Revised proposal for ancillary accommodation. Resubmission of K/10/17/HH
Fynings Middle Way Kingston Gorse

Kingston Parish Council objects to this application because the proposed development:

Drawing: LOCATION / BLOCK PLANS

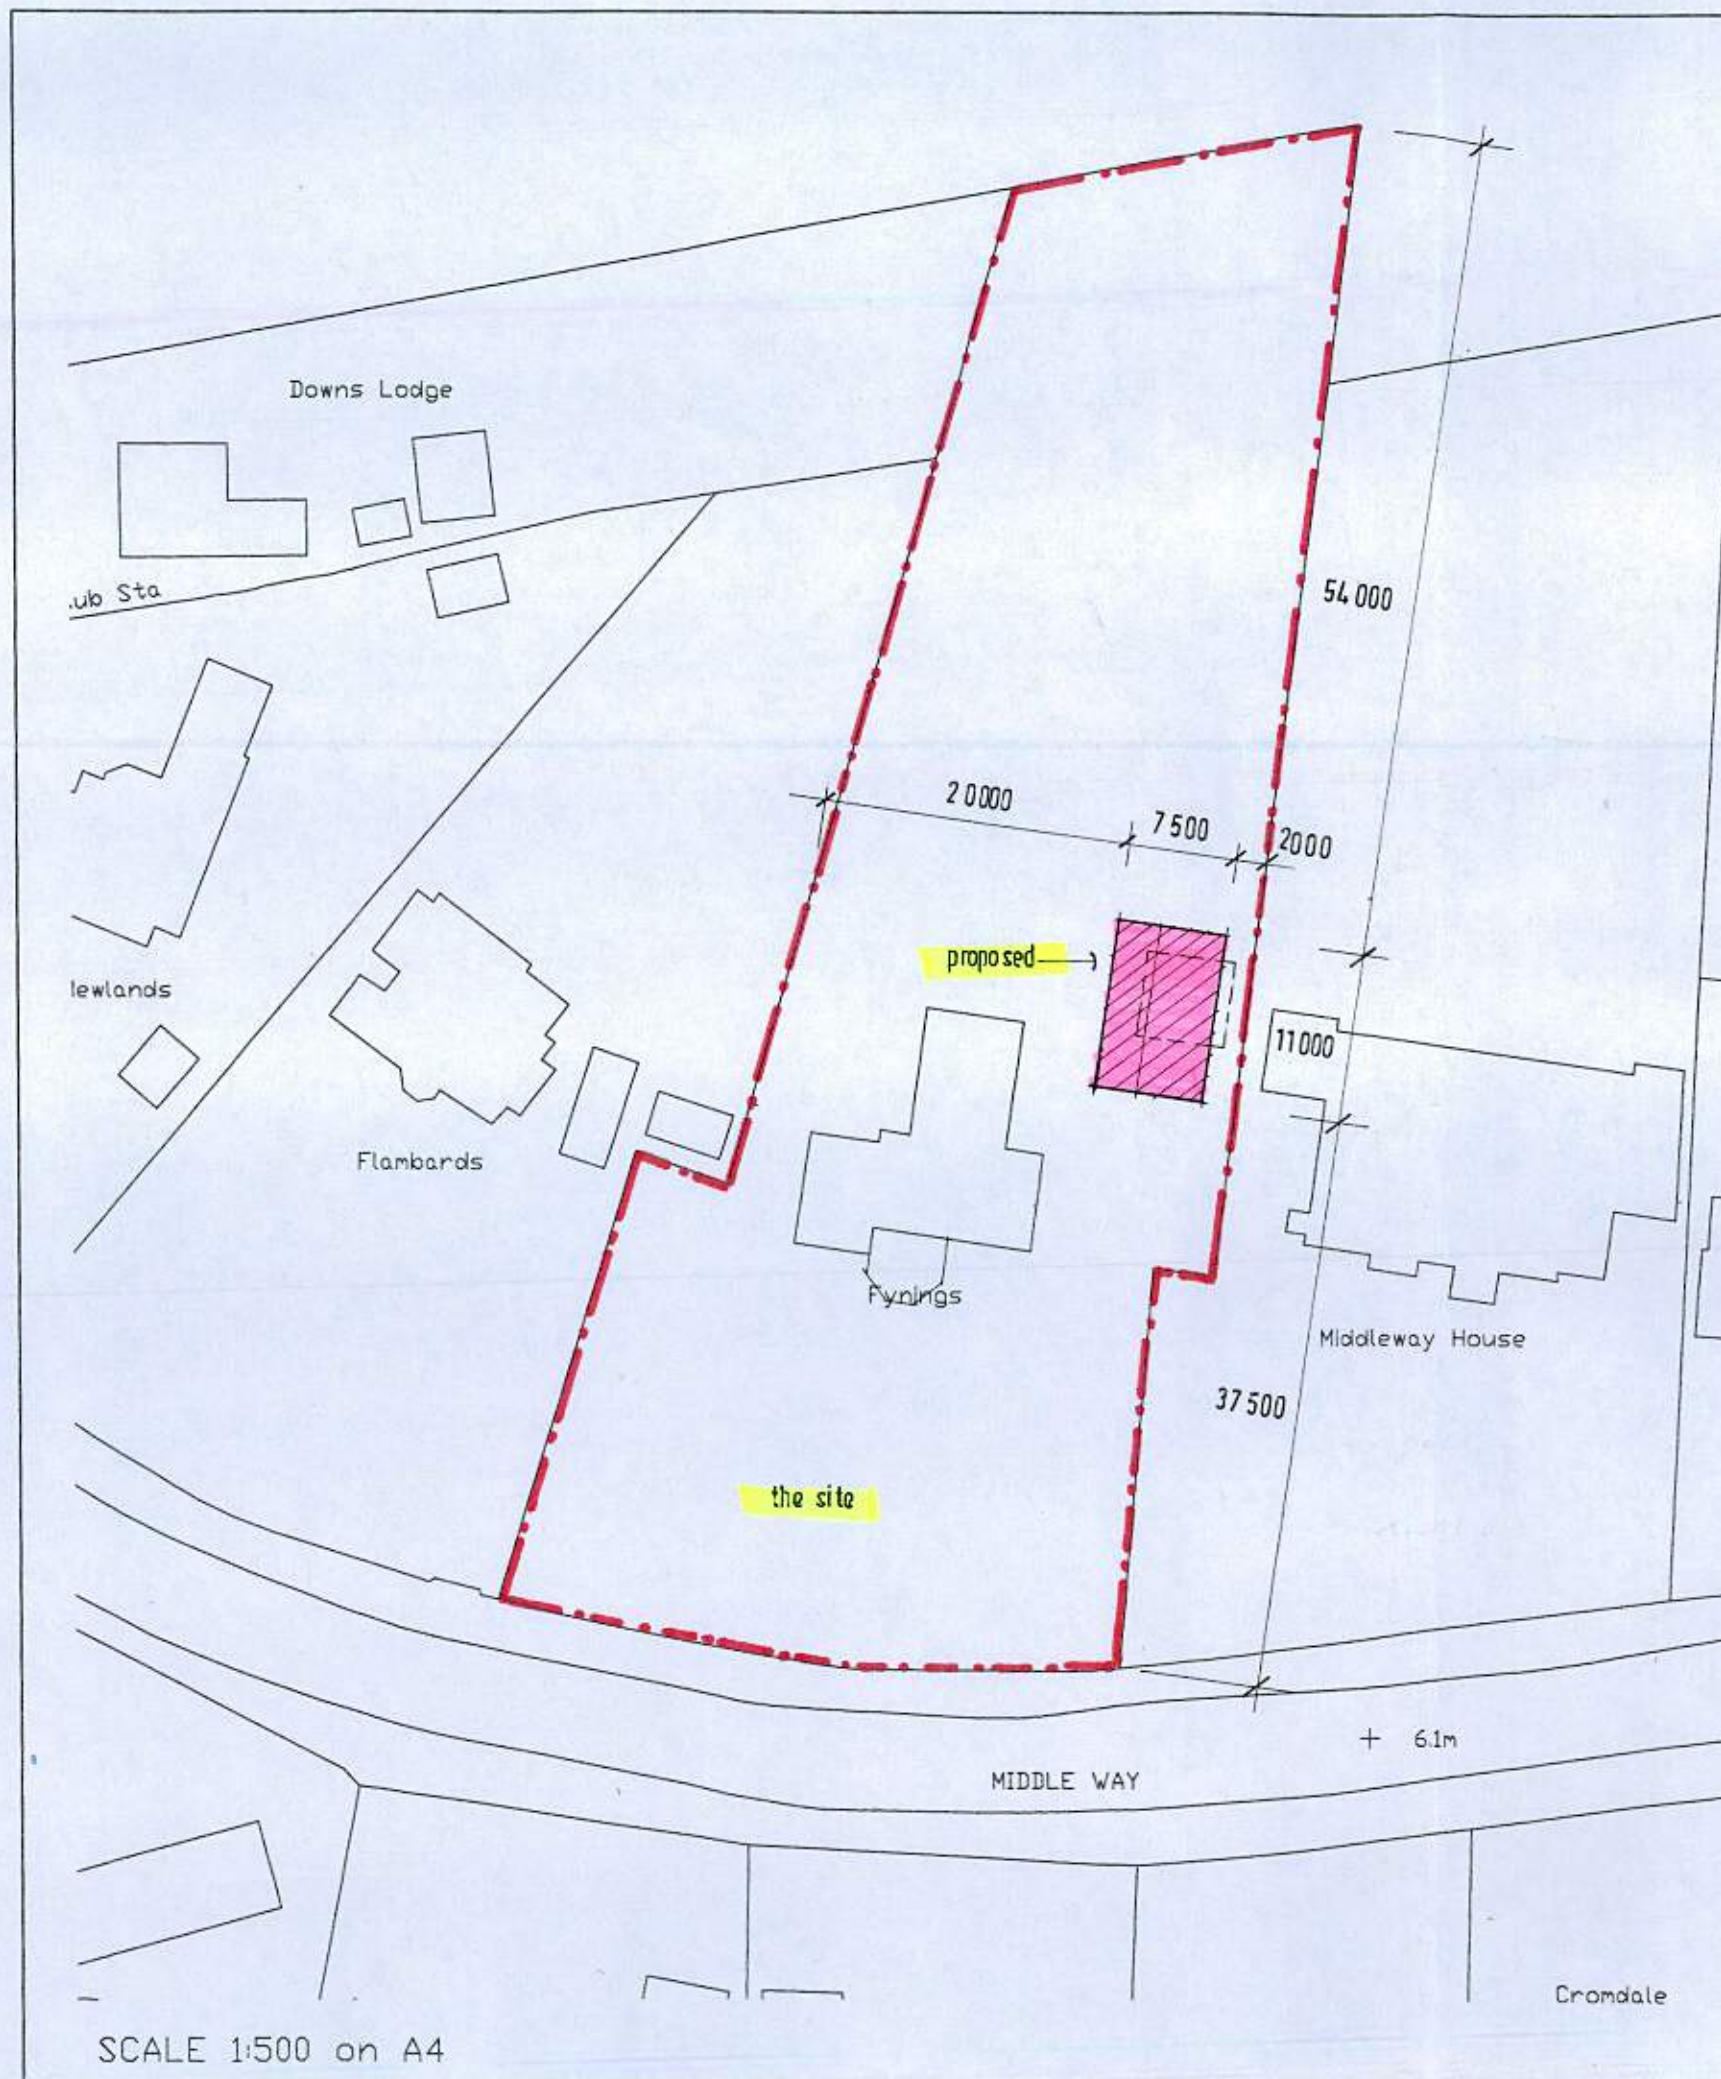
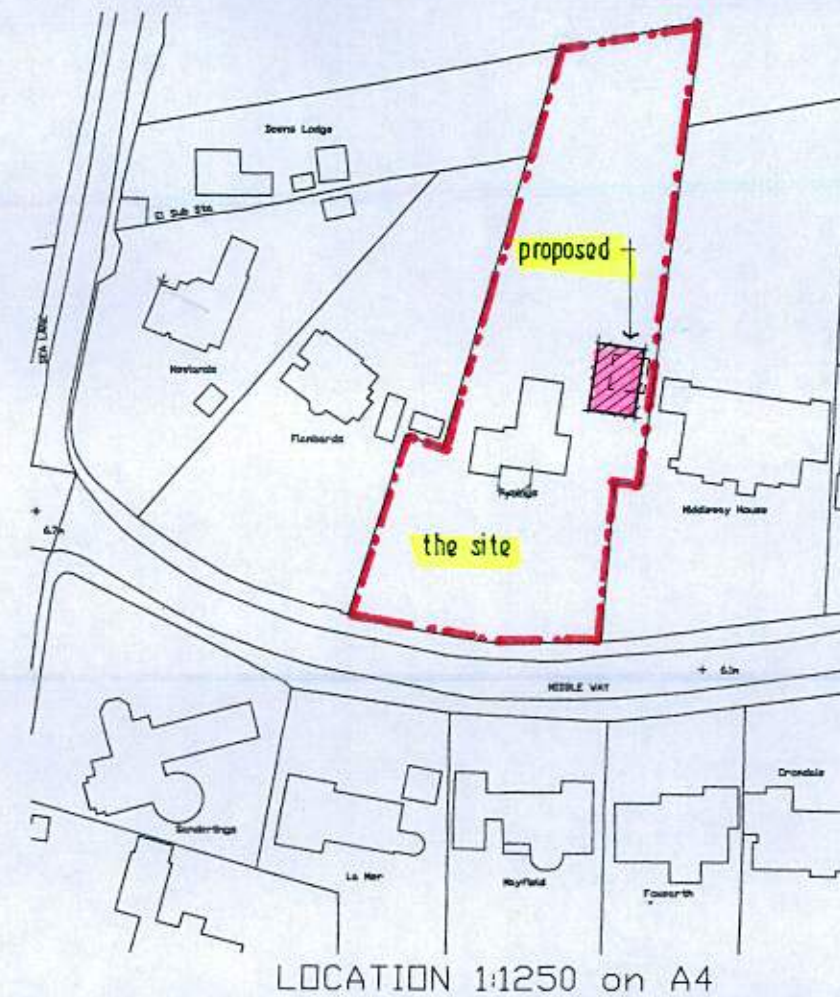
*is out of scale to the main dwelling it is intended to be ancillary to
will be forward of the building line of the existing garage
will be overbearing to neighbouring properties due to its height and bulk and proximity to
the eastern boundary
will result in a loss of light to the living rooms of the neighbouring property.
is contrary to the Kingston Neighbourhood Plan Policy KPNP 7 Design & Development
sections 1 and 2.*

*If Arun District Council, despite the objections above, is minded to approve this application
we ask that there is a condition that the use of this building is ancillary to the main
dwelling, and that the new build should not be forward of the building line of the existing
garage*
